Application No: FG/89/22/HH
Site Address: 4 East Mead Ferring BN12 5EA
Description of works: Single storey rear extension.

Thank you for your internet representation made on 18th June 2022 which has been recorded as an objection with the comments as follows:

Client	MR ELIJAH JOSHUA PARAZO		
Project	PROPOSED REAR EXTENSION 4 EAST MEAD FERRING WEST SUSSEX BN12 5EA		
Drawing	PROPOSED GROUND FLOOR PLAN & ELEVATIONS		
Scale	Date	Drawn	
1:50 & 1:100 @ A1	17.05.22	TP	
Drawing No.	Revision

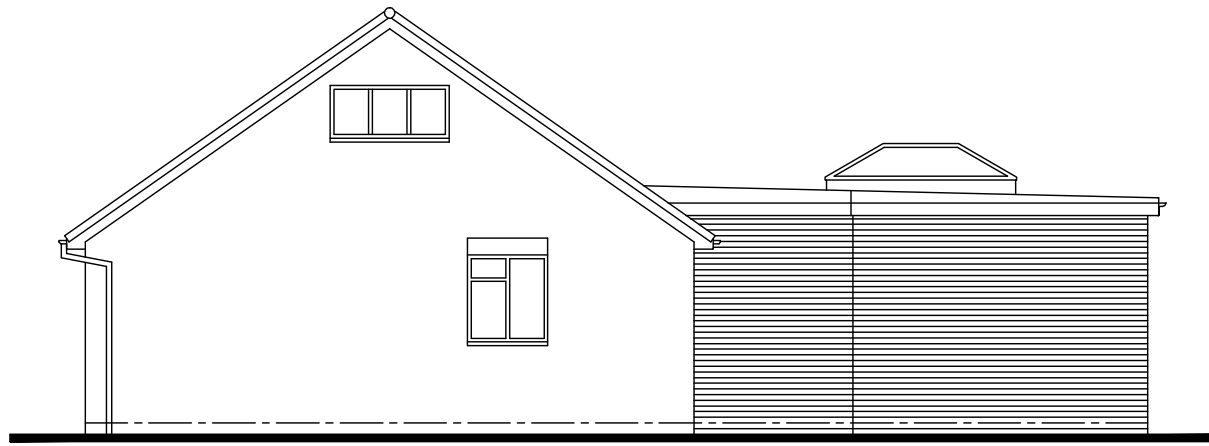
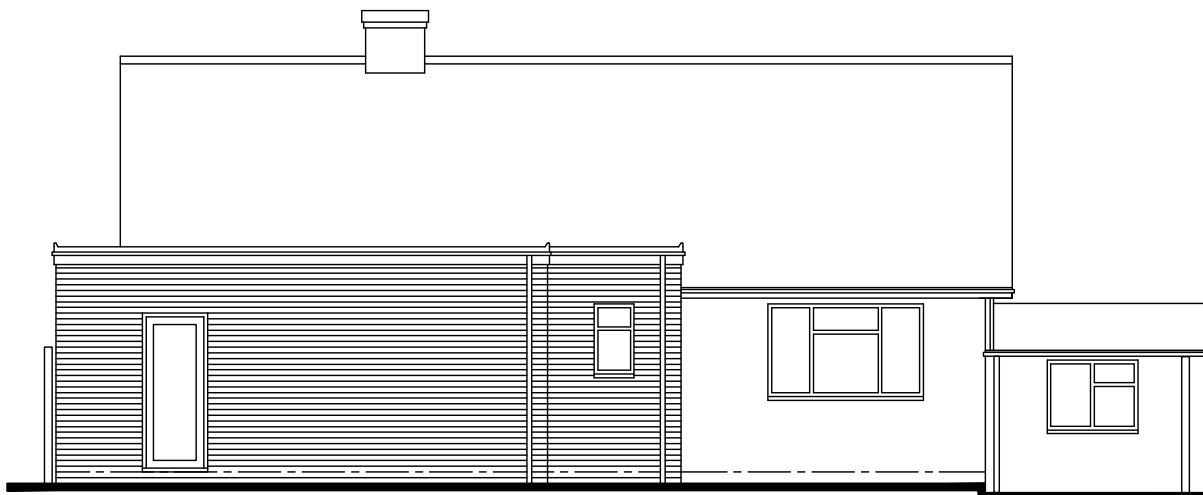
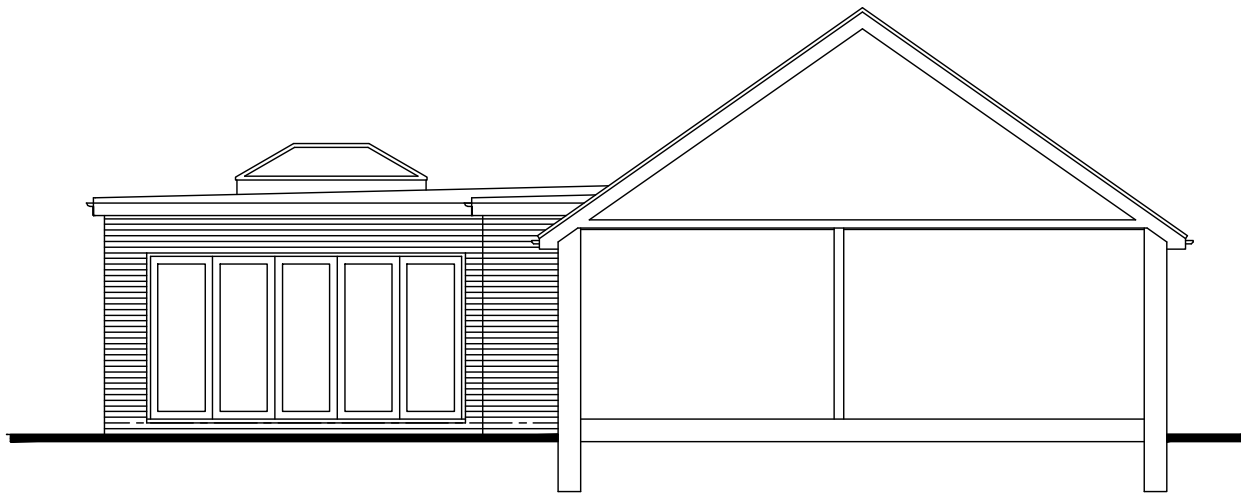
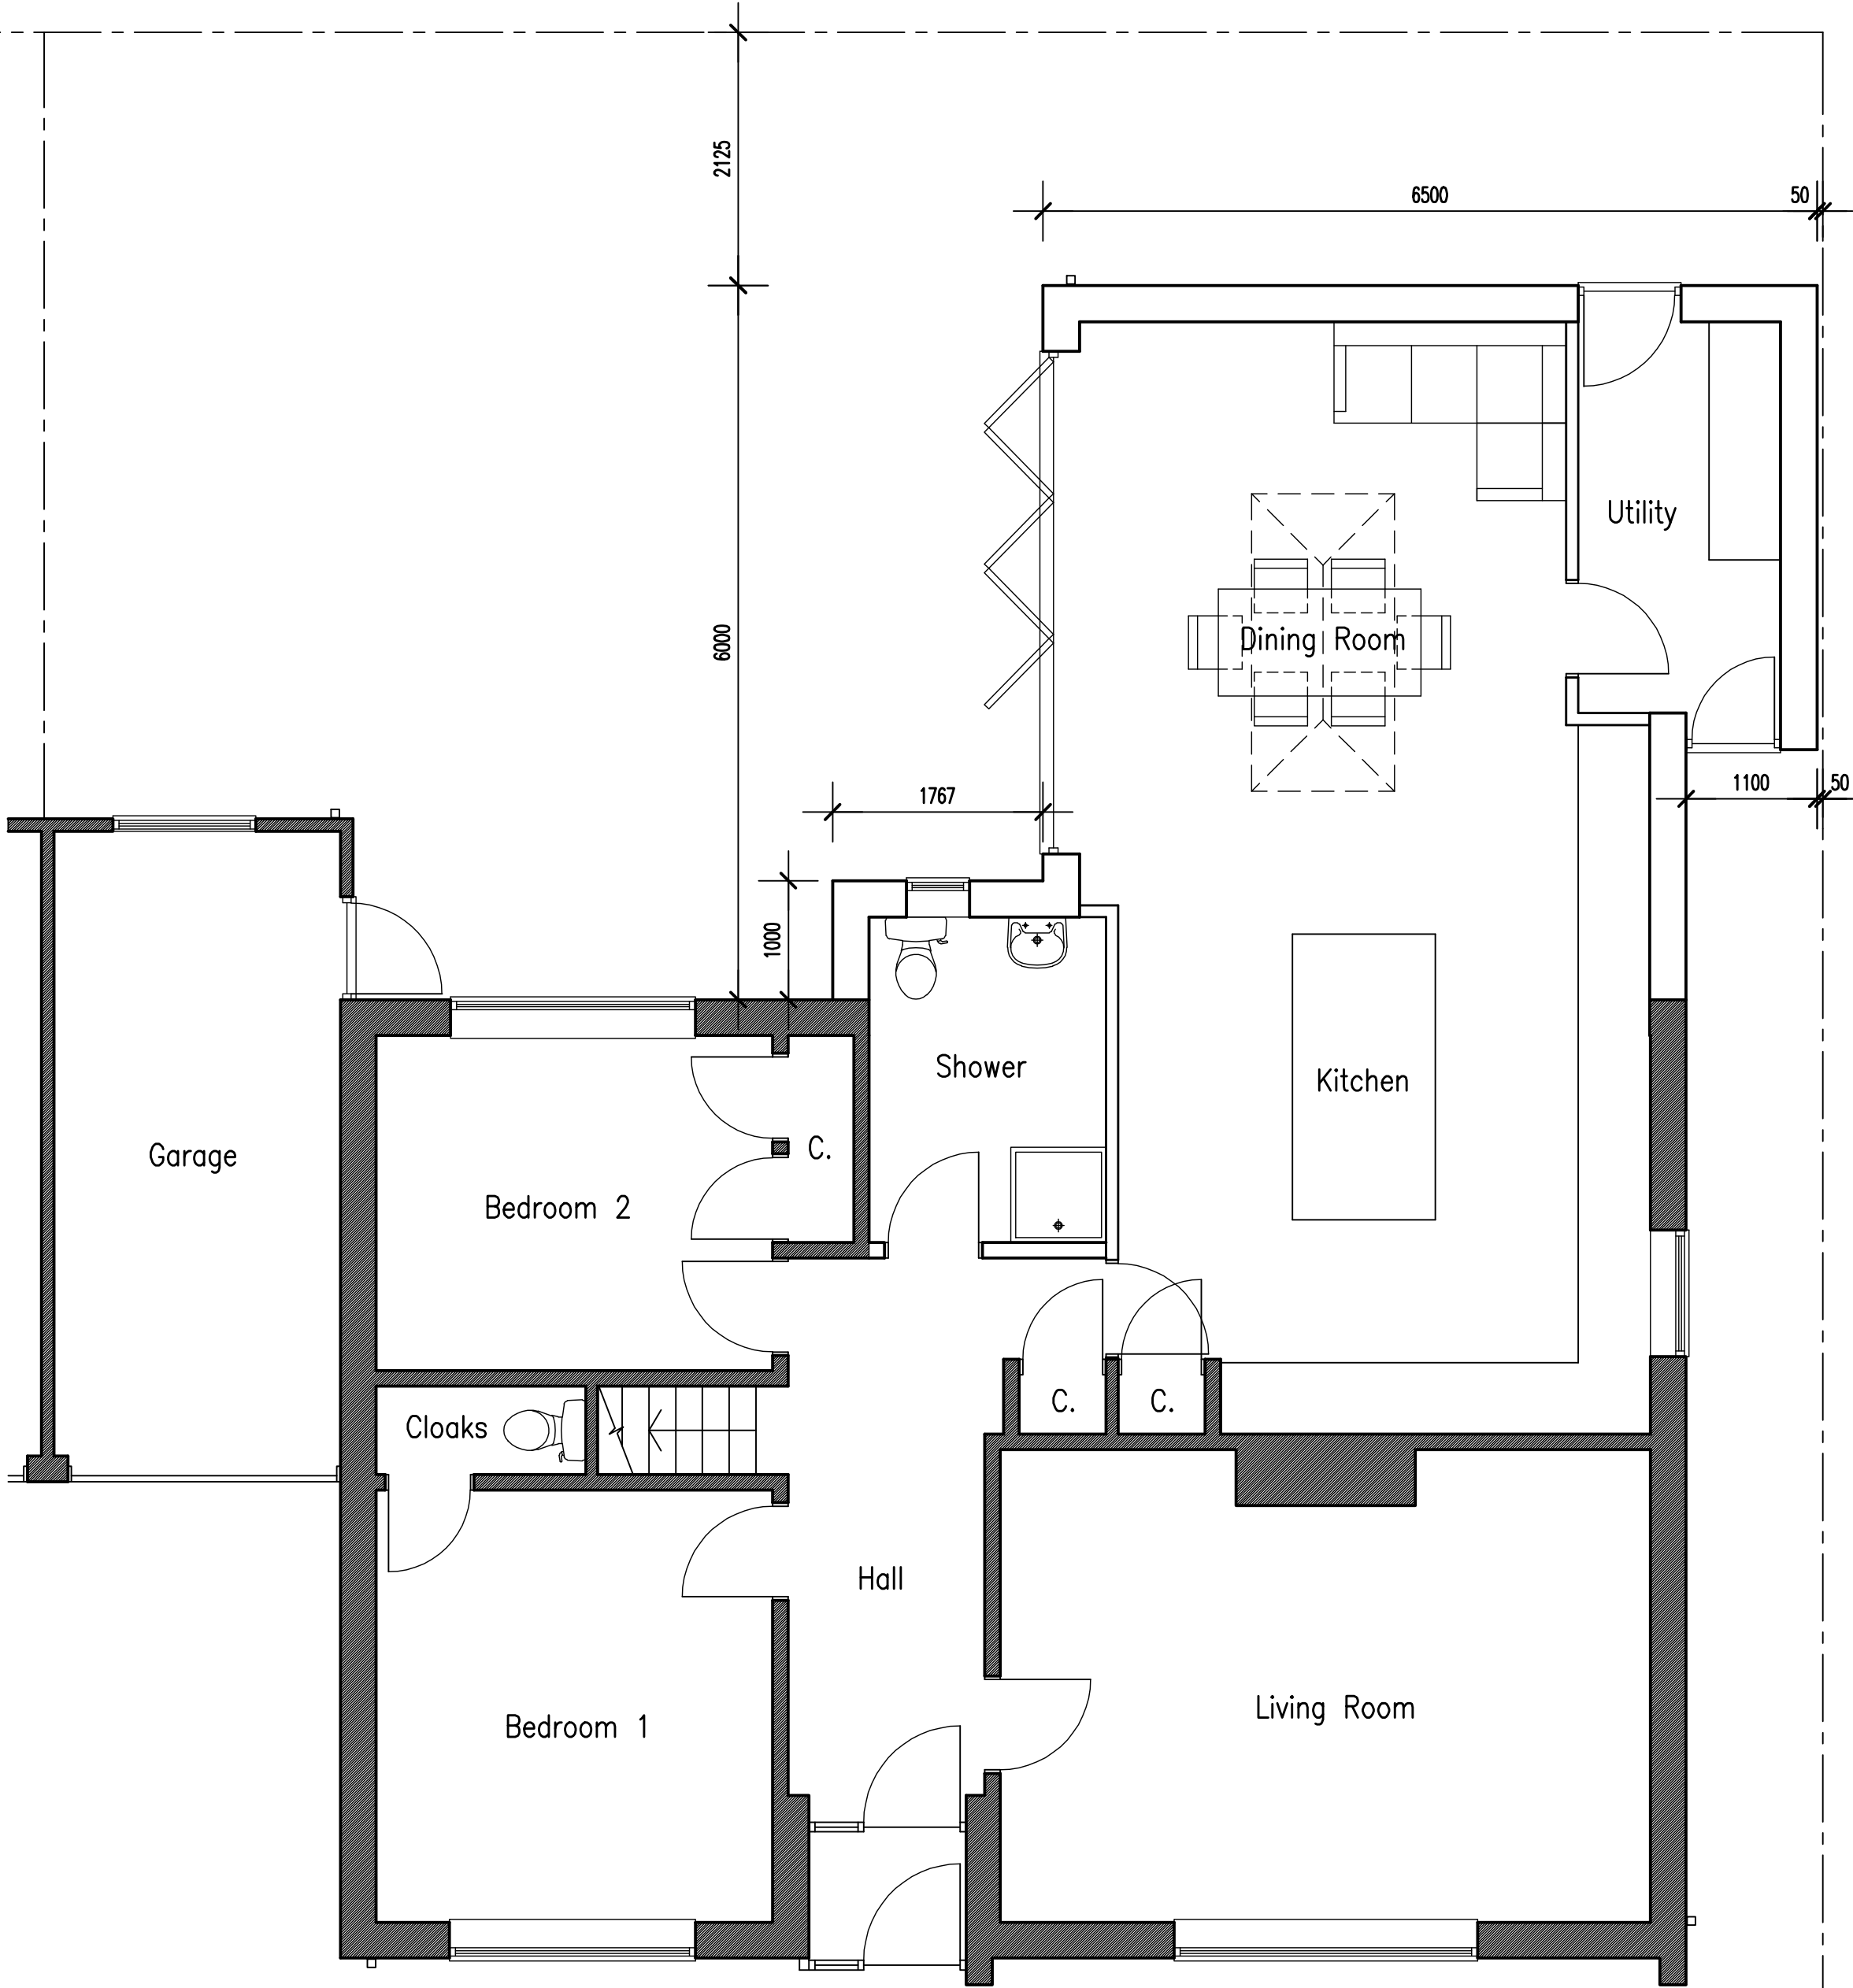
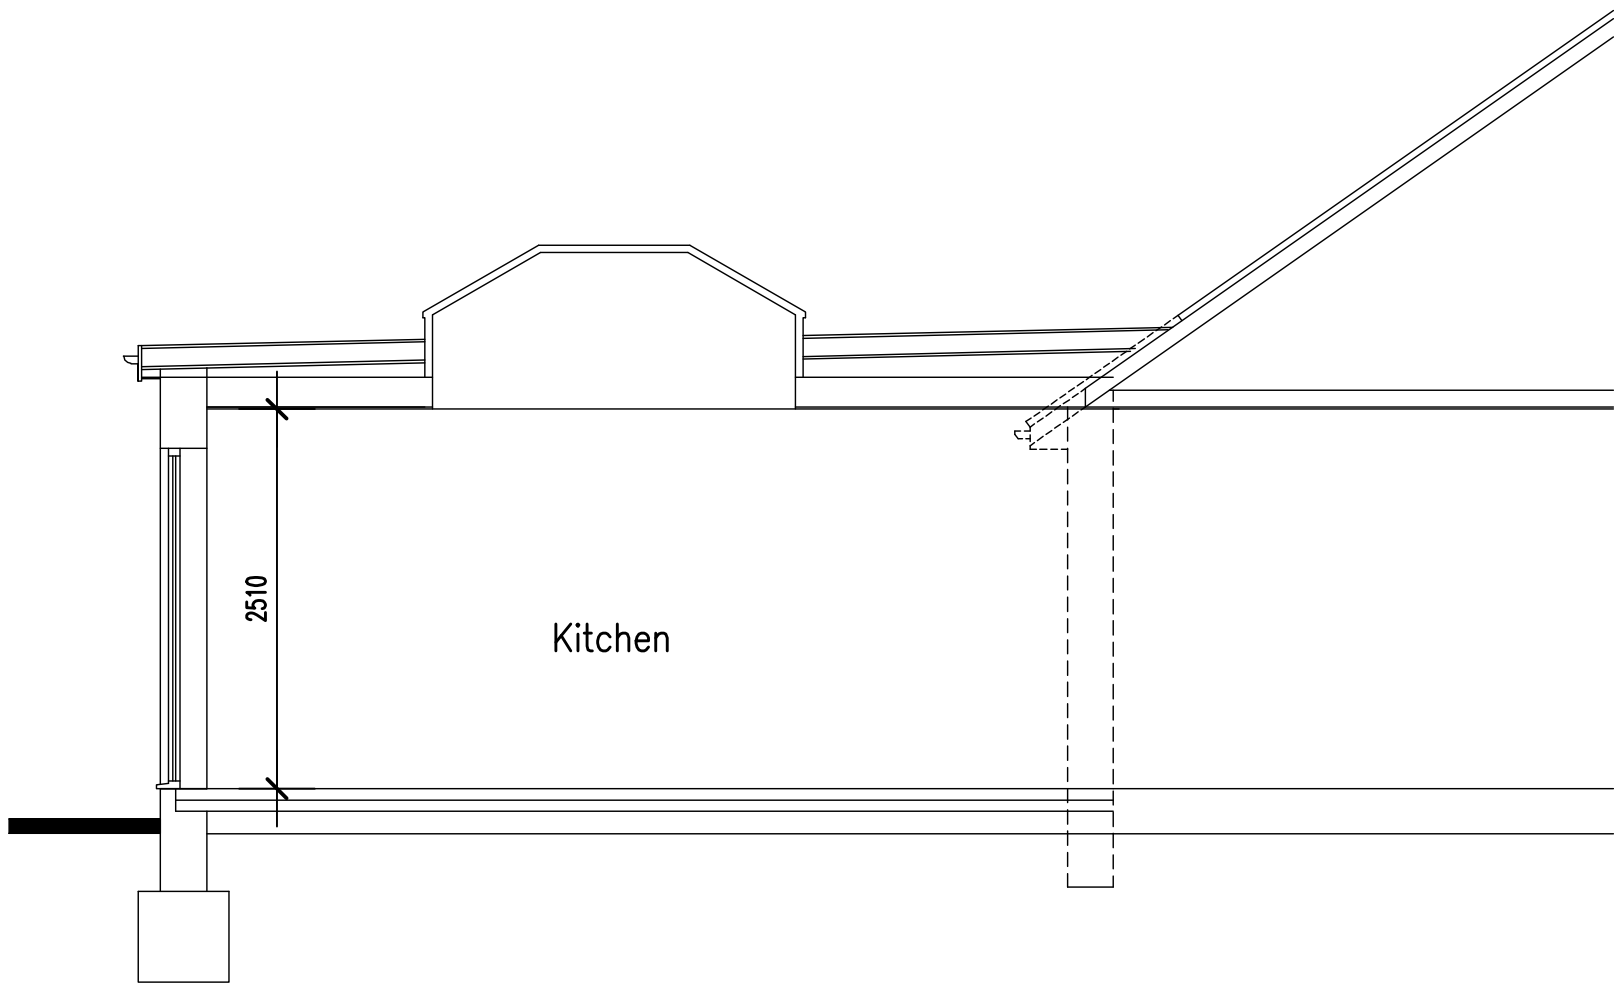
Is this extension going to affect our boundary line and afternoon daylight ? Is this a dwarf roof or a flat roof ? .
